Rezoning Transportation Analysis

Petition Number: 2023-067

Reviewer: Natalie King, PE
Natalie.King@charlottenc.gov
980-417-0206

Date	Description
8-24-23	First Review (NK)
9-20-23	Second Review (NK)
10-25-23	Third Review (NK)

TECHNICAL DATA SHEET

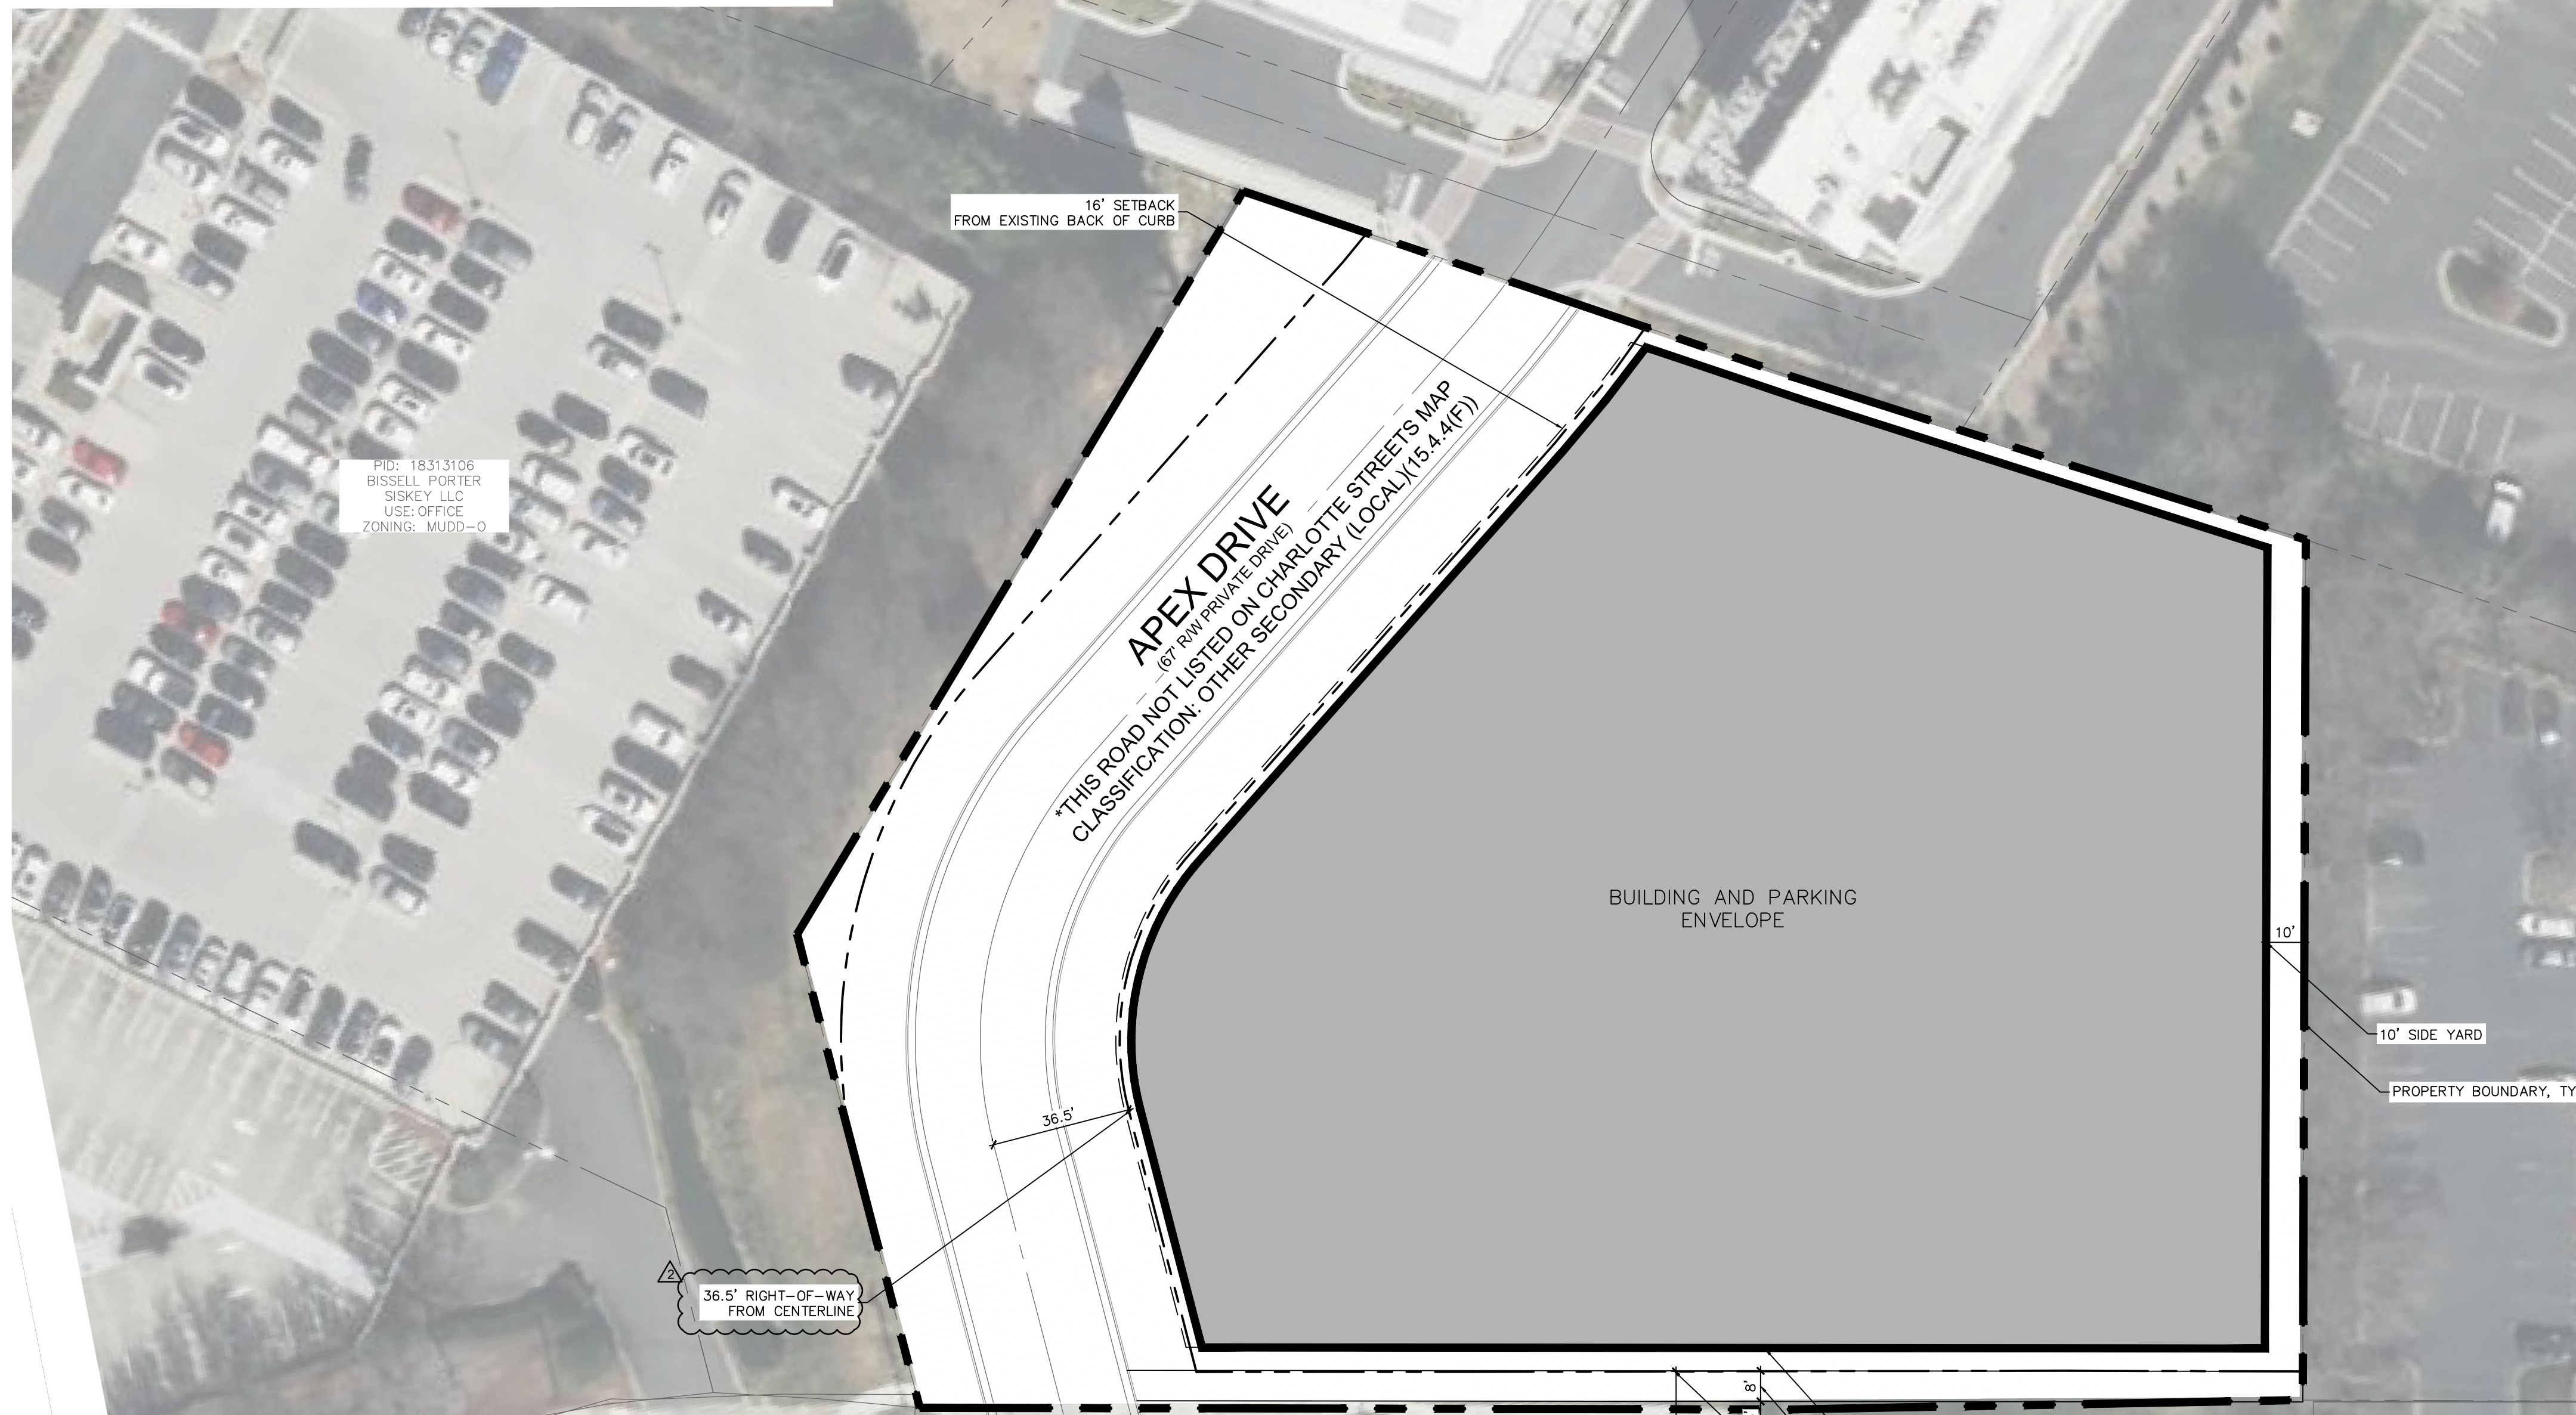
1. ~~Curbline:~~

~~Coltsgate Road Future back of curb is in its existing location.~~

~~Label and dimension the curb and gutter from the centerline for each road on the site plan.~~

3. ~~Revise site plan and conditional note(s) to commit to dedicate 36' 6" right-of-way from the road centerline. The site plan shall label and dimension the right-of-way from the road centerline.~~
